From: Chris Jones
Sent: 12 May 2025 13:06
To: Iqraa Malik
Subject: RE: Request for further information A/76/25/HH
Attachments: Smith block plan 1.pdf

Unfortunately, this application is still invalid as the block plan also requires the dimension from the proposed extension to the rear boundary. Please review and amend.

Proposed block plan scale 1:500

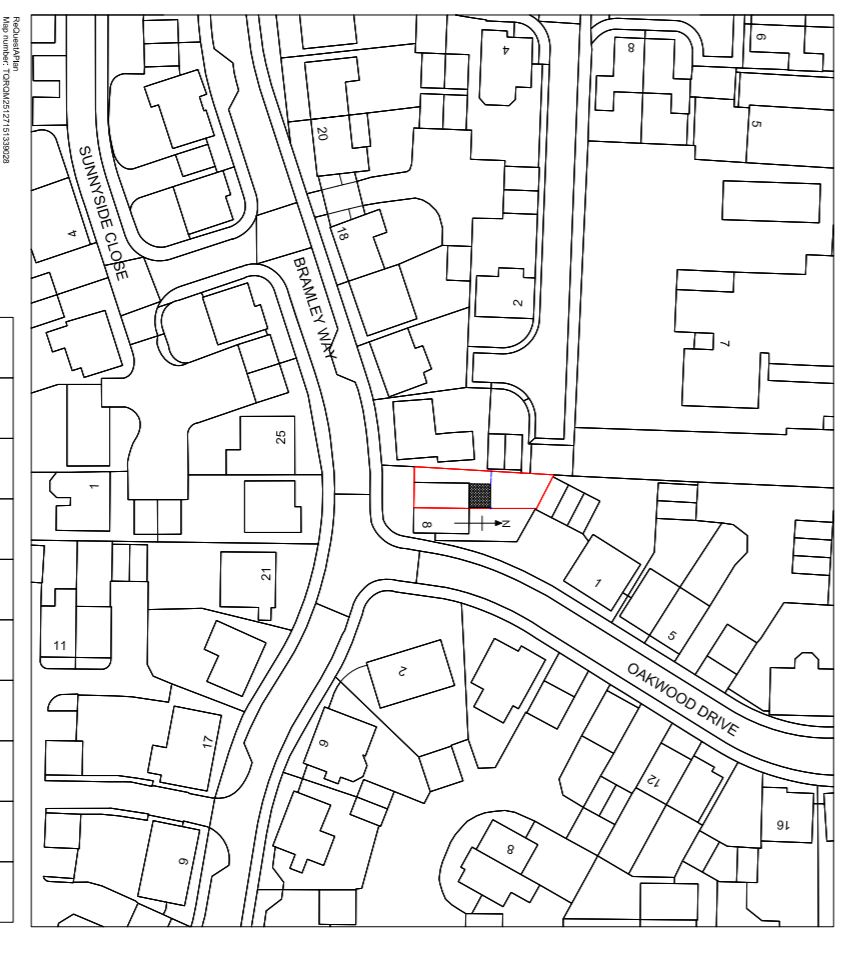
Could you please add the dimension to the rear boundary? That is the one that is outstanding.

Dear Iqraa,
Please see attached. This is the best I can do to show the distances to the boundaries.

To whom it may concern,
I have added the distances to the boundaries on both the proposed elevations and the block plan. If you need anything else please let me know.
